May 31, 2022

City of Marysville
Community Development Department
80 Columbia Ave
Marysville, WA 98270
Attn: Chris Holland

Re: Quality Auto Center- Response to Building Design Comments (PA22005)

PRELIMINARY SITE PLAN

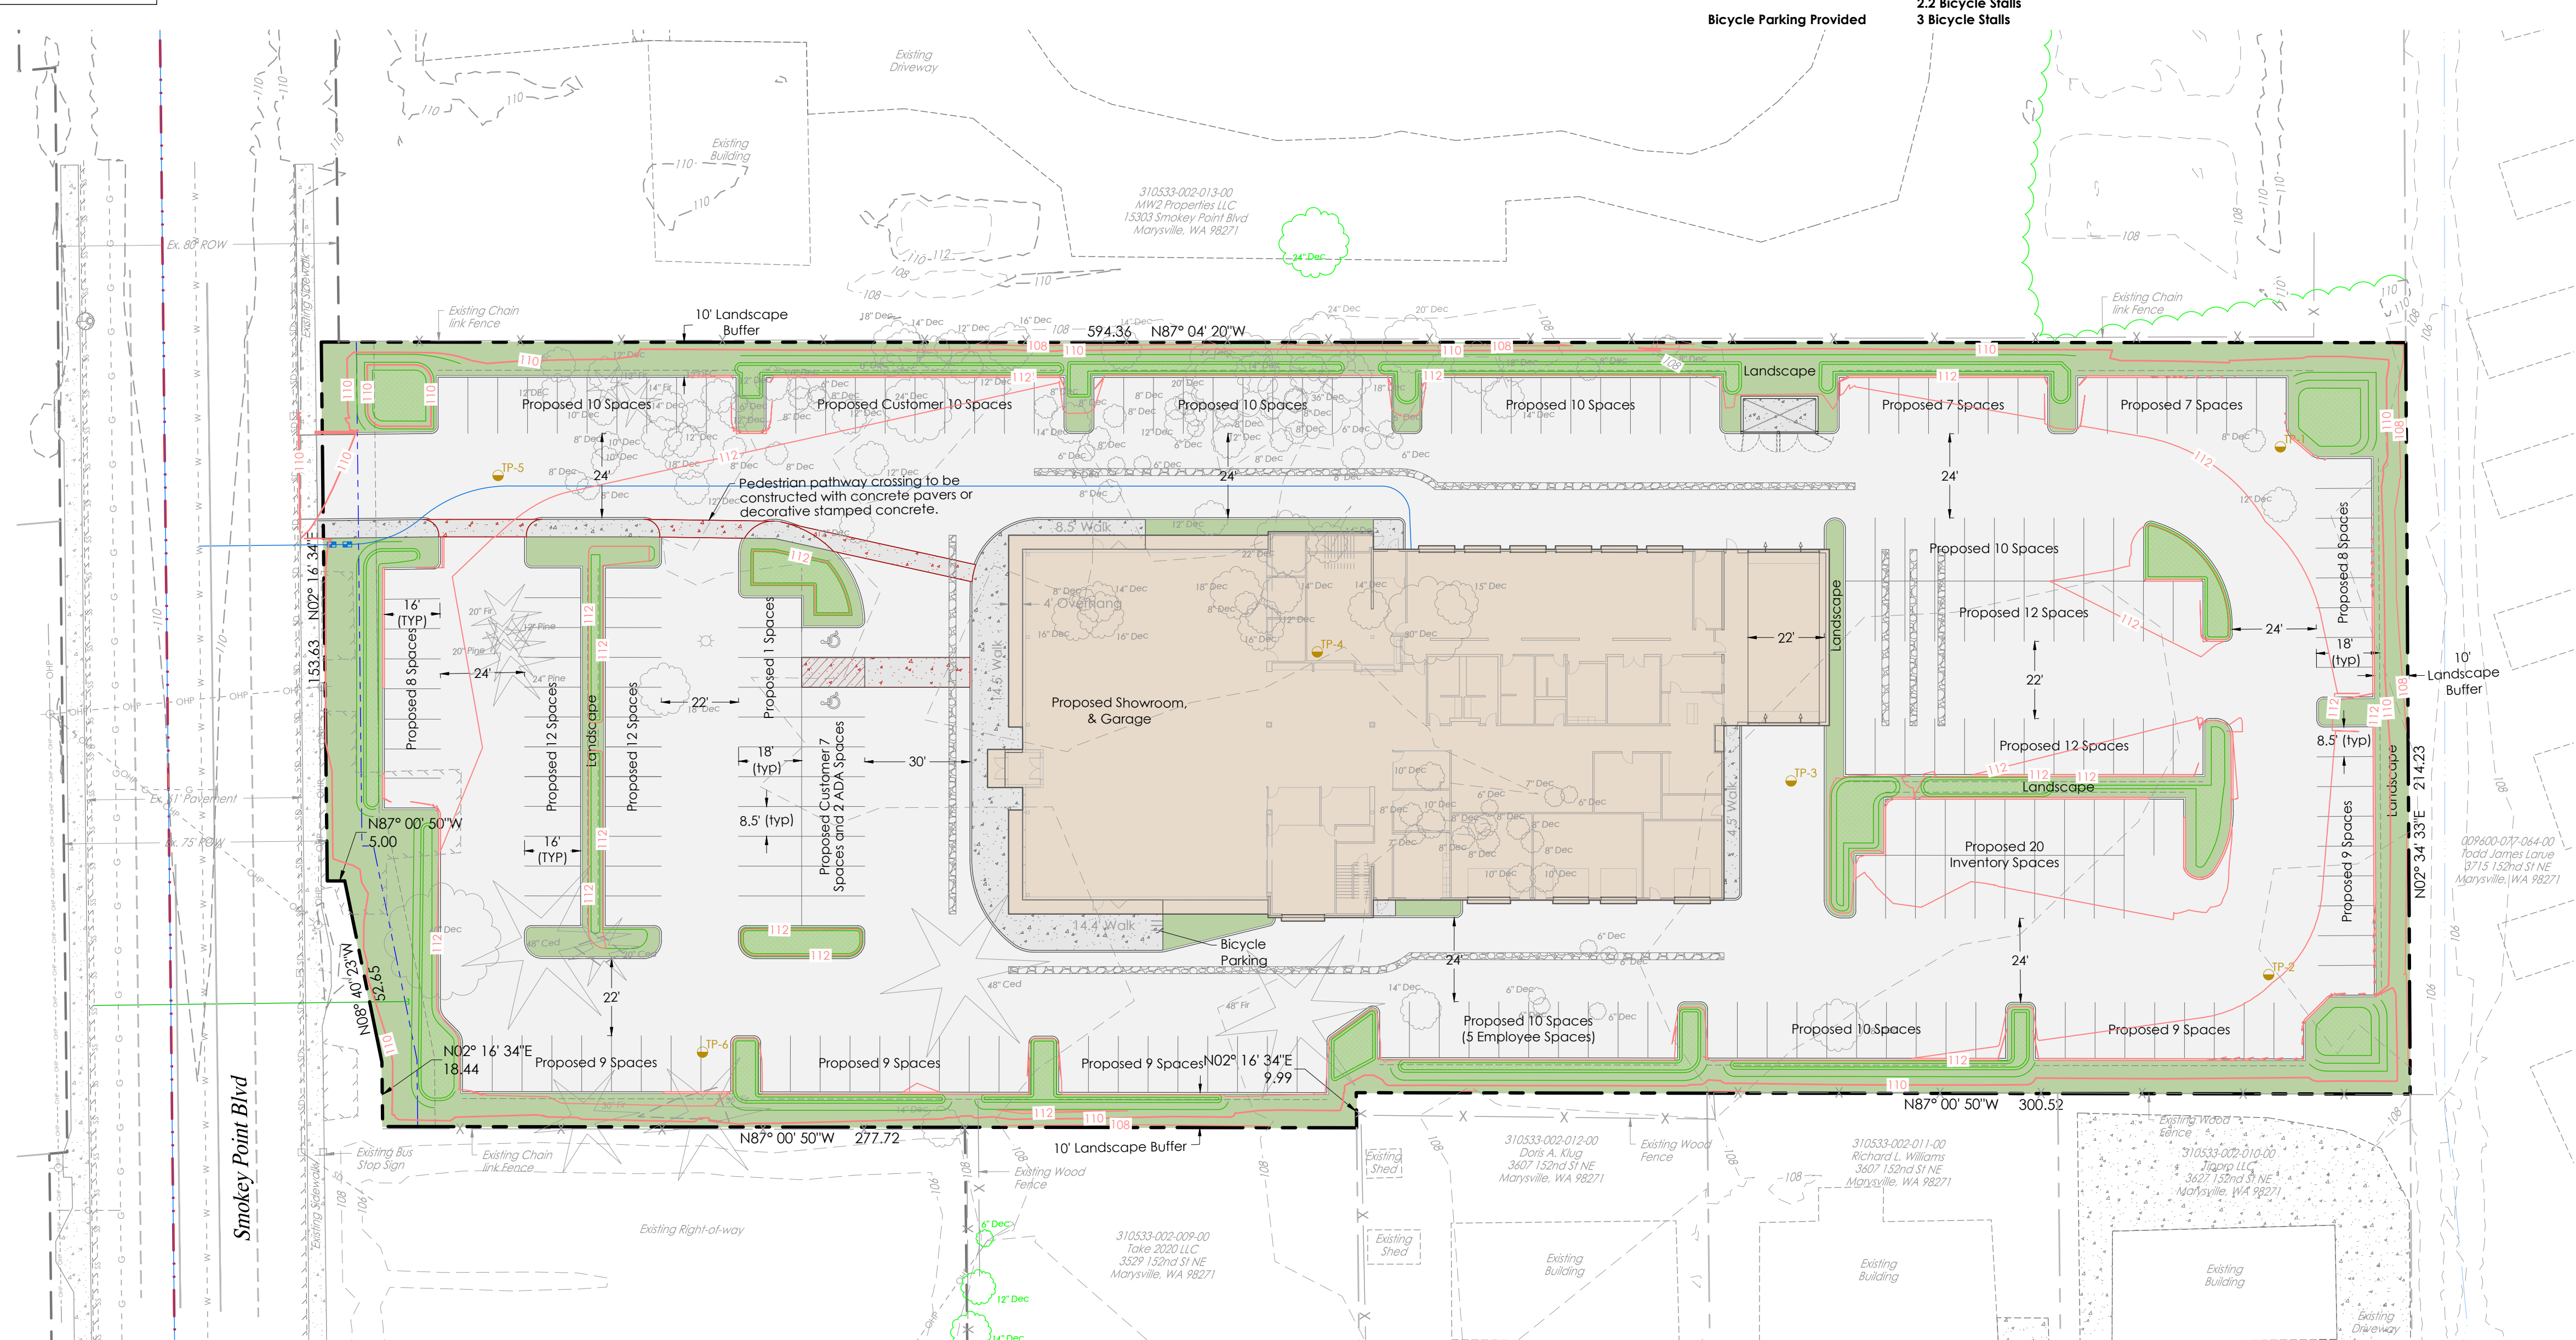
3. Pedestrian pathway between the street sidewalks and the main entrance.

We located the pedestrian pathway along the entry drive for two reasons: First, the grades are highest the NW corner of the property at the sidewalk which allow the walkway to be relatively level and meet ADA accessibility without ramps to the street sidewalk.

Second, this site requires up to 5 feet of fill so we have a retaining wall at the front edge of the front yard parking area. Because of this and the required Storm Water Management Facility, the grade change and serious negative impacts to the drainage system make access directly out to the street from the main entry a design problem that needs to be avoided.

We recognize the desire to have the most direct pathway possible, but in this case that does not work well due to site topography, storm water management, and fill as noted. We do meet IBC and WA State accessibility requirements as currently designed.
